**Response to Request for Further Information – Wallgrove Business Hub (SSD 50972718)**

This letter has been prepared by *Keylan Consulting Pty Ltd* (Keylan) on behalf of *Western Sydney Parklands Trust* (the Applicant) in response to Department of Planning, Housing and Infrastructure's (DPHI) request for further information dated 3 June 2025 in relation to the State Significant Development Application (SSDA) at 97 – 151 Wallgrove Road, Cecil Park (SSD 50972718).

Figure 5: Concept Masterplan

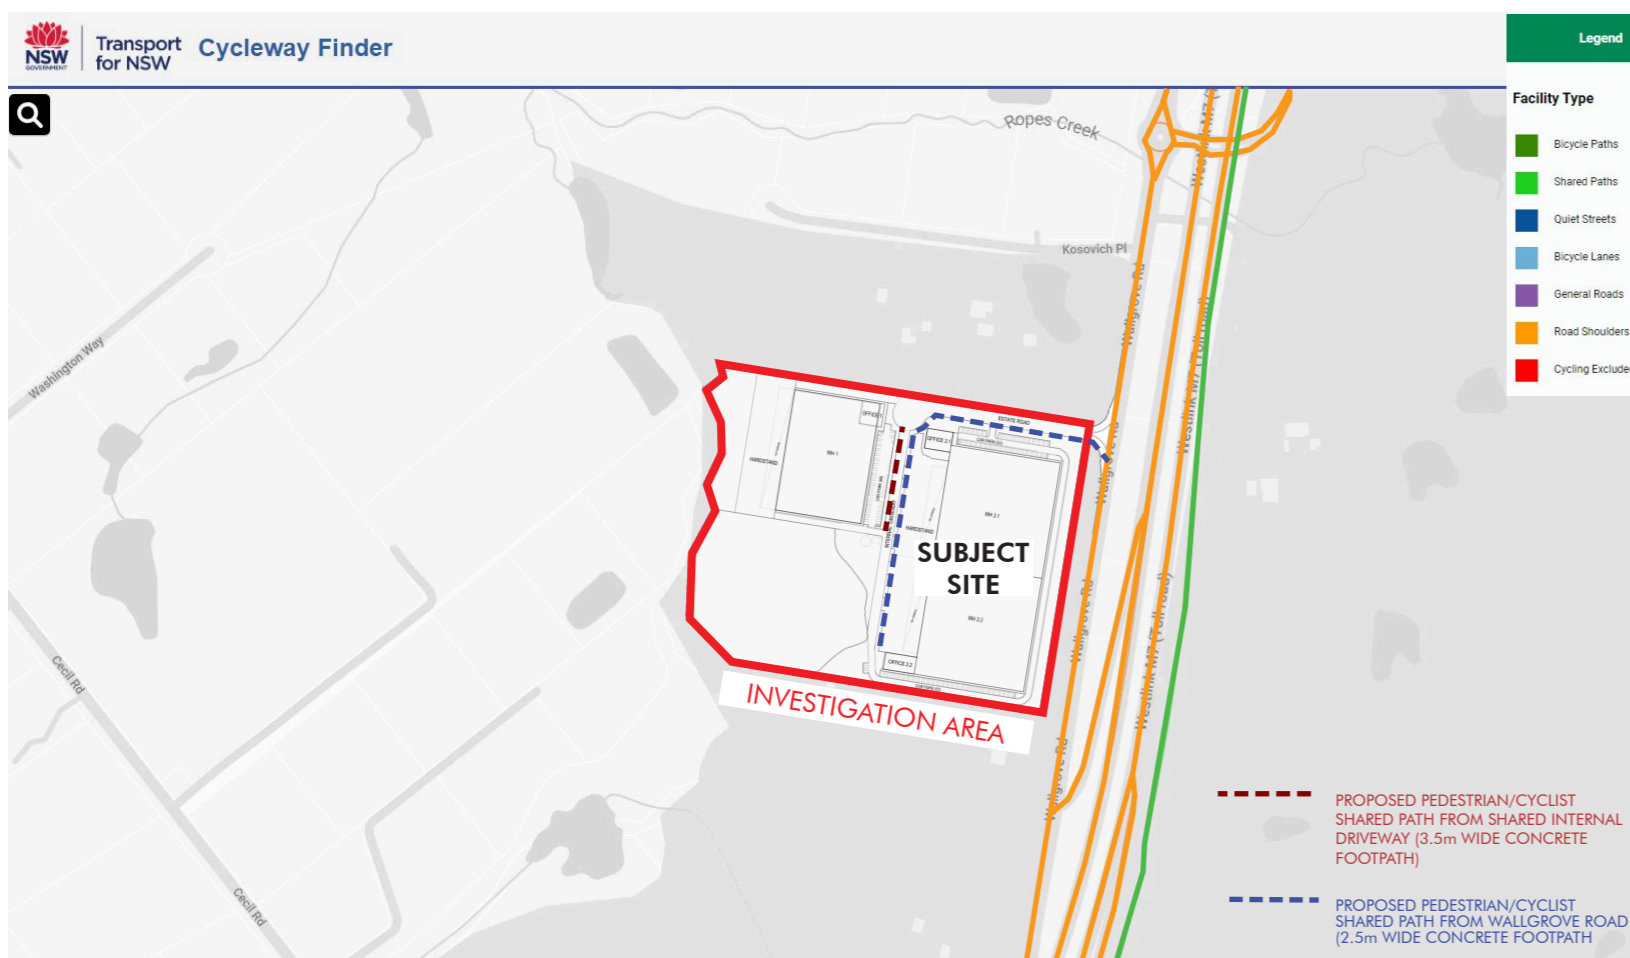
6.	<p>The updated bushfire assessment indicates a continuous perimeter access road around both buildings. However, the concept master plan does not show a connection between the two lots, which conflicts with the access route identified in the bushfire assessment. Please either update the master plan to include this connection or revise the bushfire assessment to accurately reflect the proposed access arrangement.</p>	<ul style="list-style-type: none"> <li>An updated Bushfire Assessment and Fire Vehicle Access Paths has been prepared by Peterson Bushfire (Appendix 3).</li> <li>The revised plan details the revised fire vehicle access paths, travelling across the carpark and hardstand for the respective Warehouses.</li> <li>An extract of the proposed route is provided in Figure 2 below.</li> </ul>  <p>Figure 2: Proposed fire vehicle paths (Source: Petersons Bushfire)</p>
